Our ref: RA/2022/144175/01-L01
Your ref: 2021/94721
Date: 09 March 2022

DISCHARGE OF CONDITION 4 (FLOOR/GROUND LEVELS AND DRAINAGE) OF PREVIOUS RESERVED MATTERS APPROVAL 2019/91638 FOR ERECTION OF 27 DWELLINGS PURSUANT TO OUTLINE PERMISSION 2017/92233 FOR ERECTION OF UP TO 34 DWELLINGS – LAND AT ABBEY ROAD NORTH, SHEPLEY, HUDDERSFIELD, HD8 8DY

Scale	1:500 @ A1	Date	APR 19	Drawn	DJG
		Chk.	TC		
Dwg. No.	1305/11/03	Rev	U

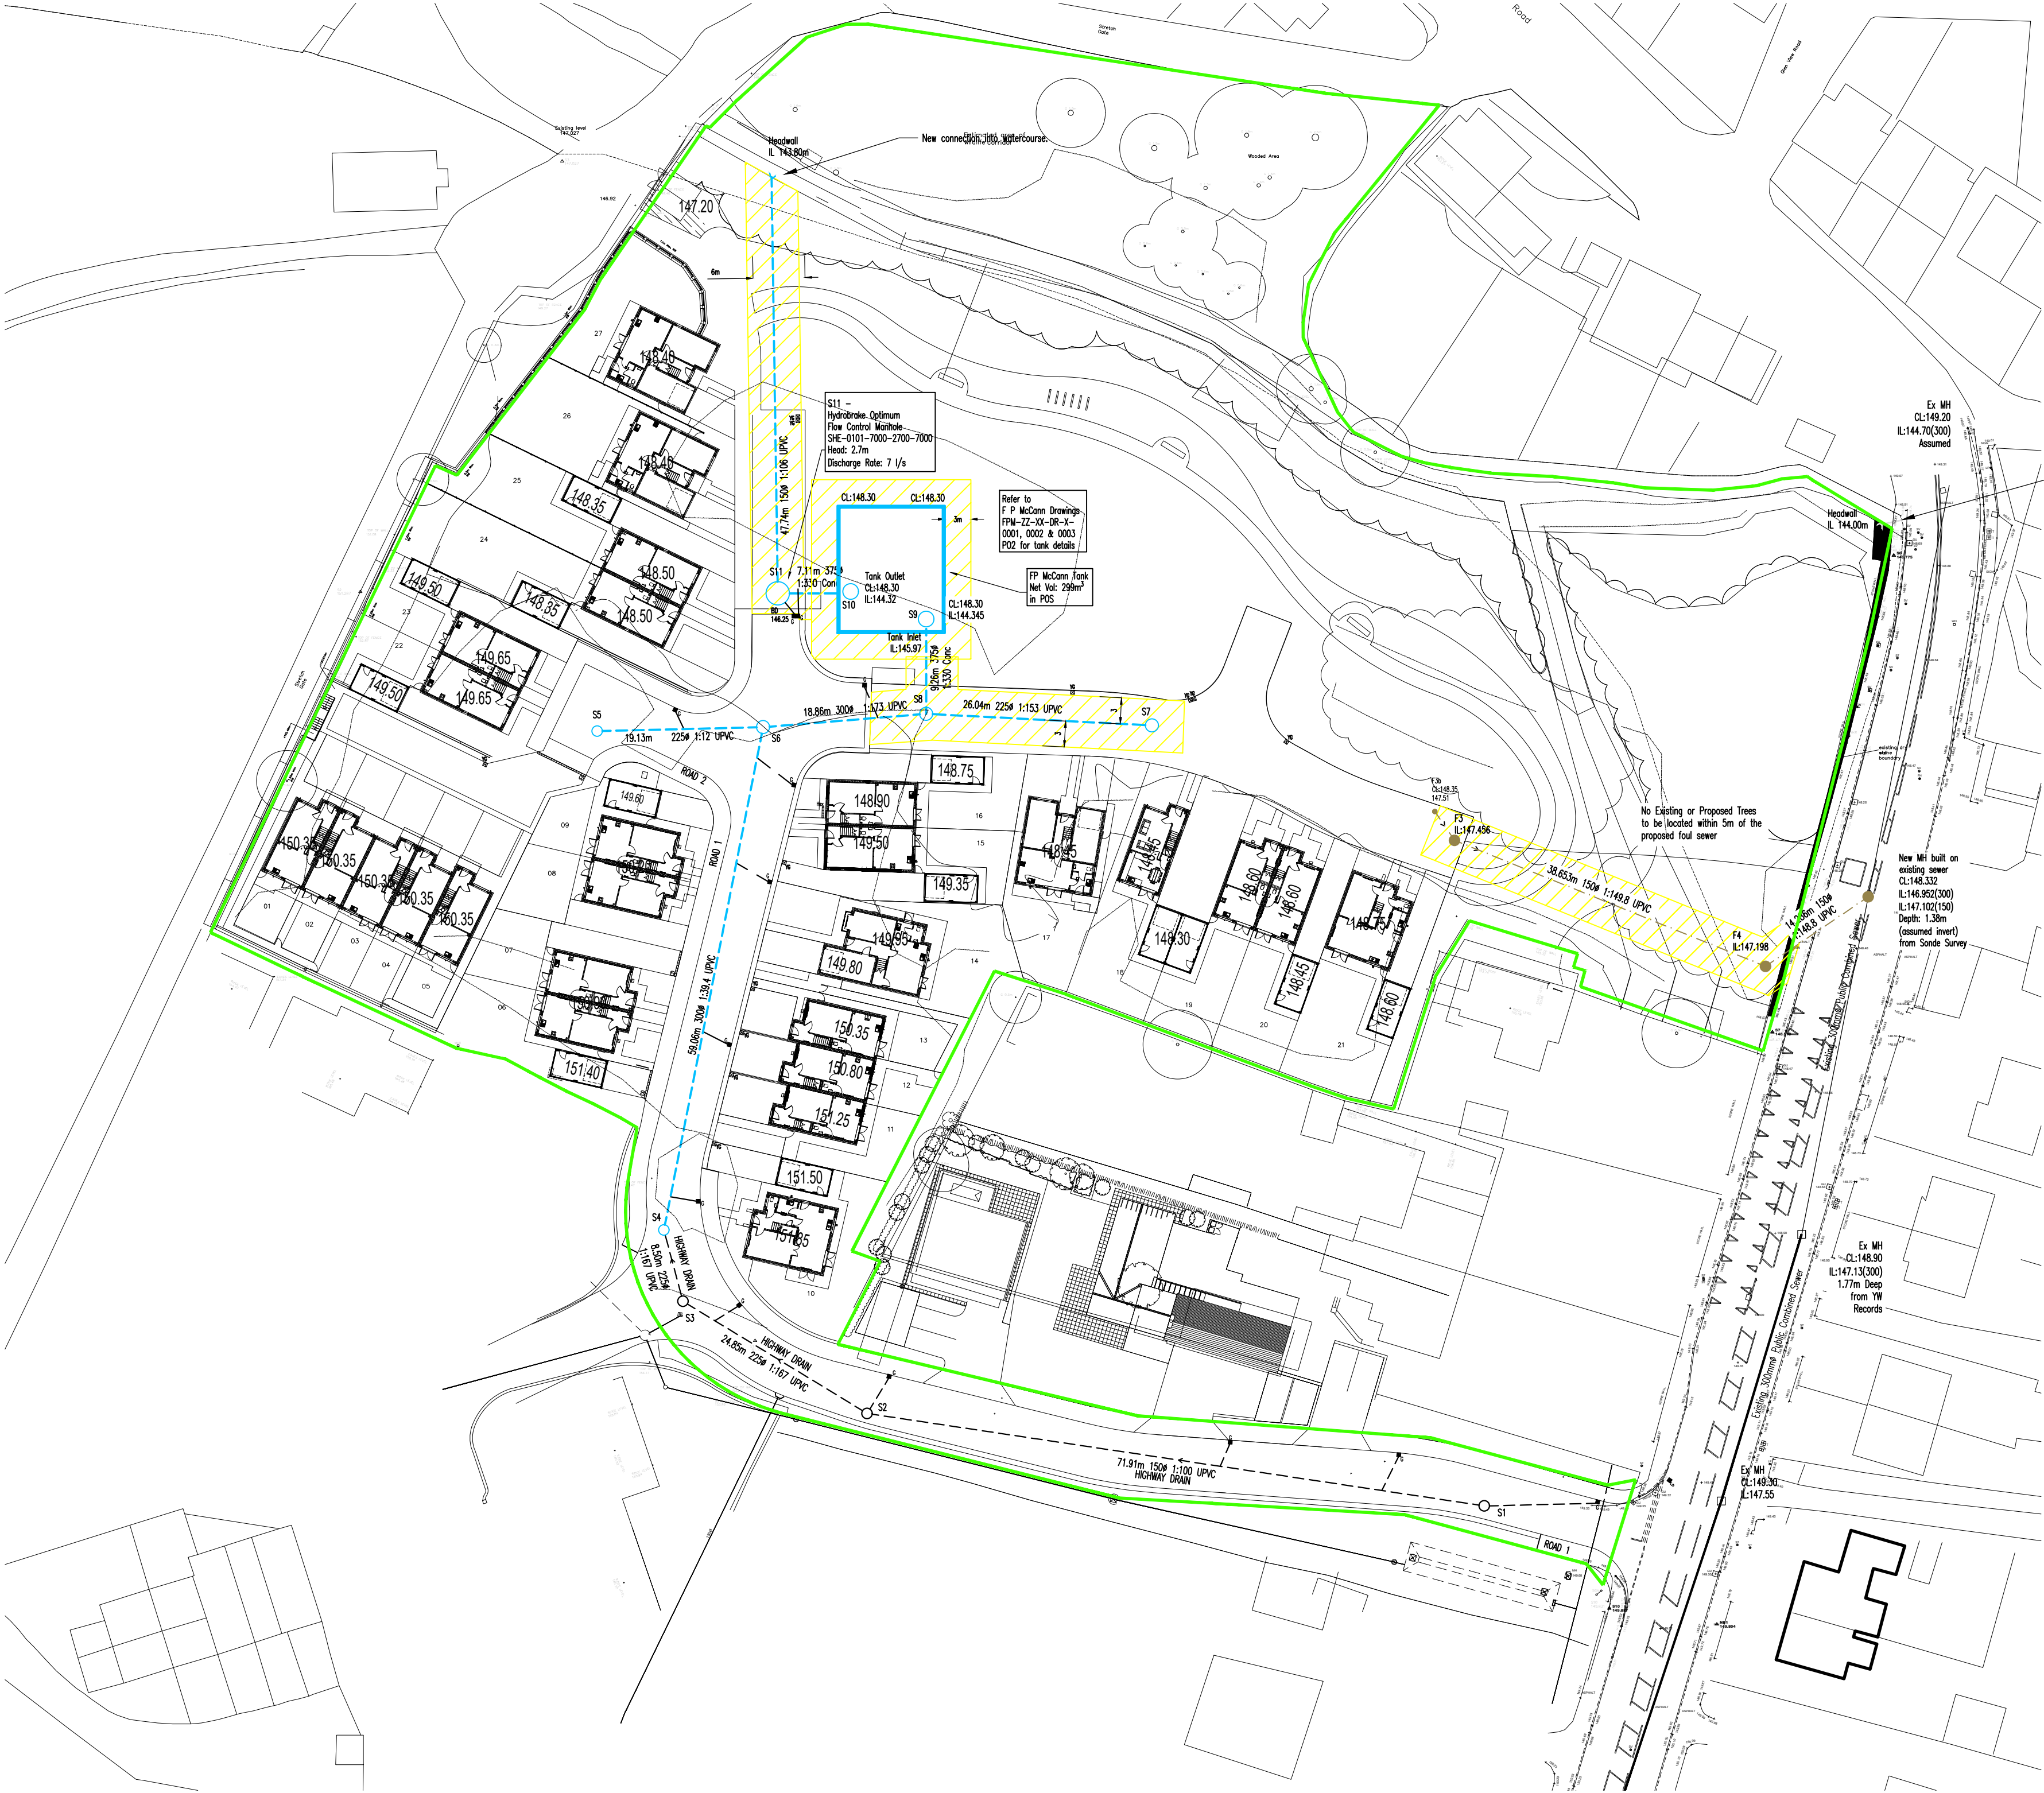
The 'Section 104 Layout' (drawing number 1305/11/03 dated April 2019 Revision U) shows finished floor levels of the residential properties are at or above 148.4 mAOD. We are satisfied that this meets the requirements of the first part of condition 23. However, the level of some of the garages is below this, which could result in water ingress during a flood. As these are not habitable spaces, we are less concerned about

the levels of the garages, the LPA may wish to discuss this further with the developer.

TITLE OFFSITE
LONGITUDINAL SECTIONS

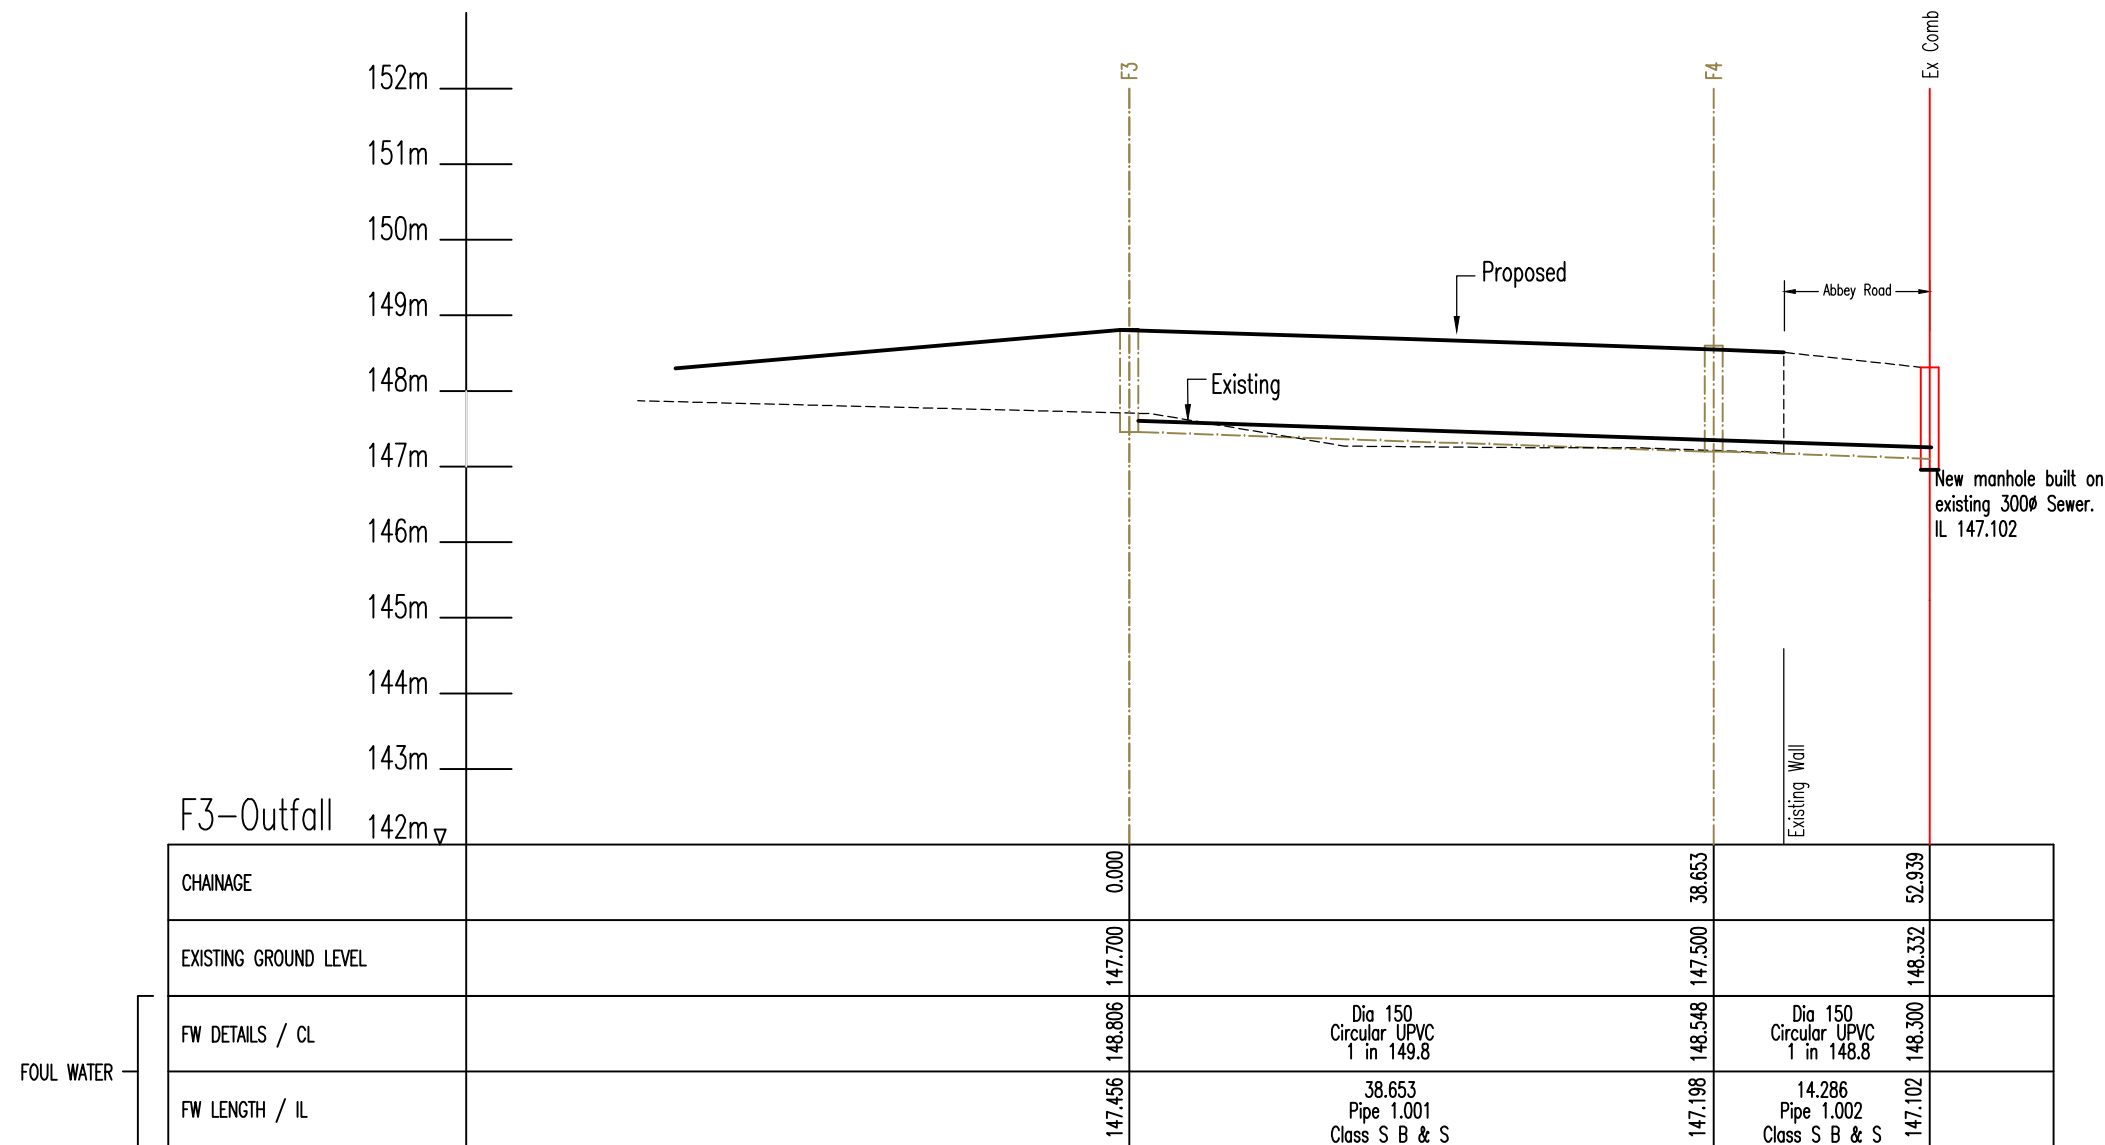
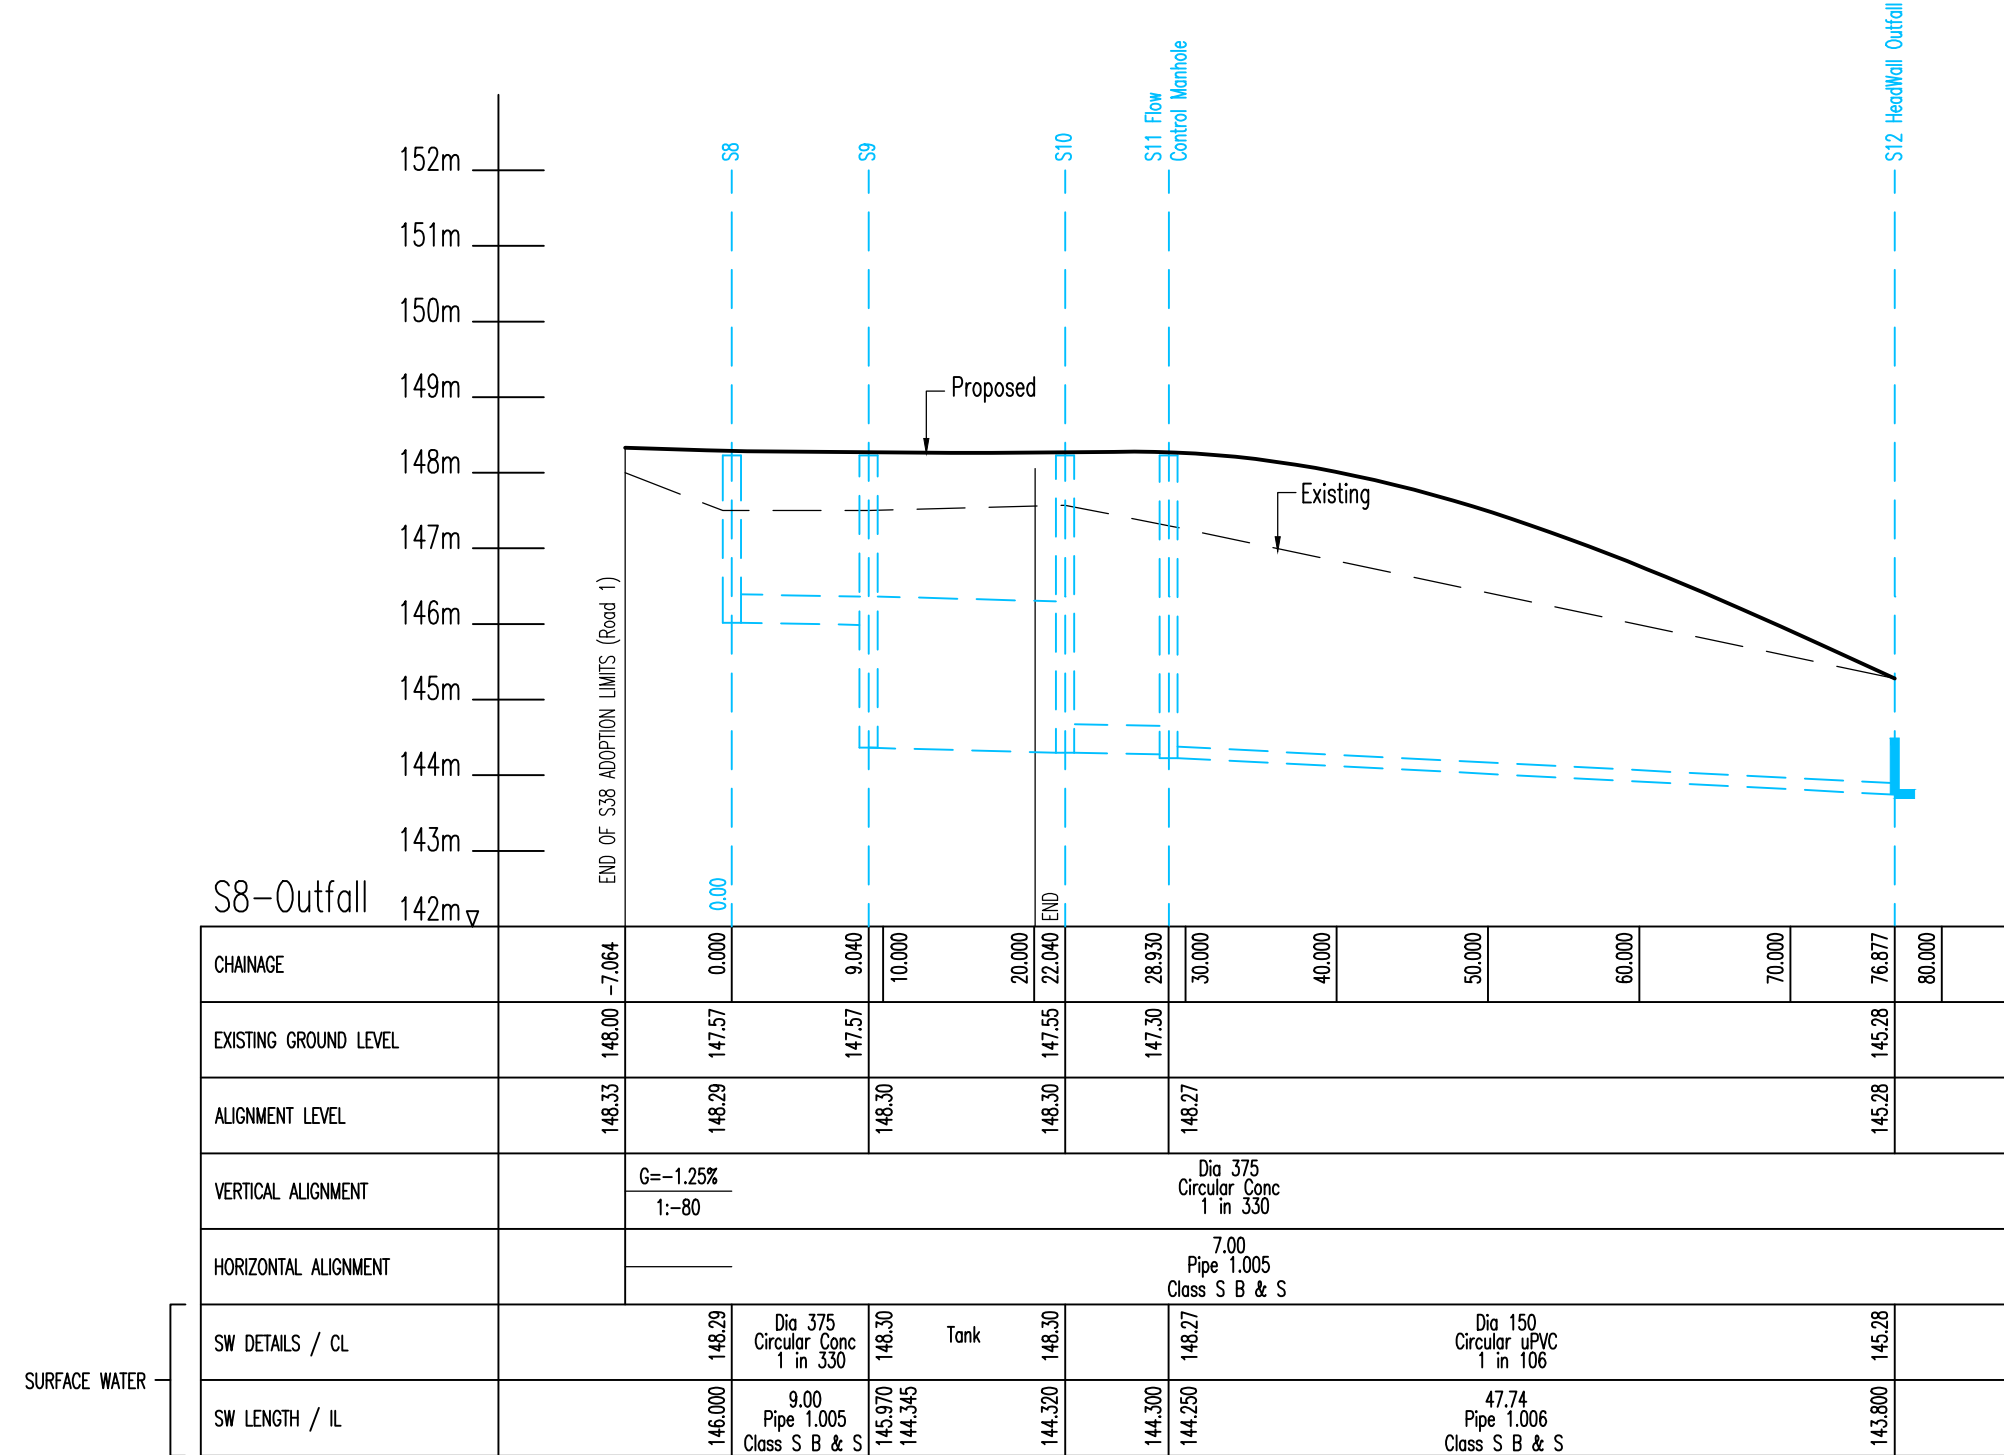
Longitude sections have been submitted to discharge condition 4 showing existing/ proposed ground levels, and ground reprofiling. However, the cross-section locations have not been referenced on a plan, so it is not clear where the ground level reprofiling is taking place.
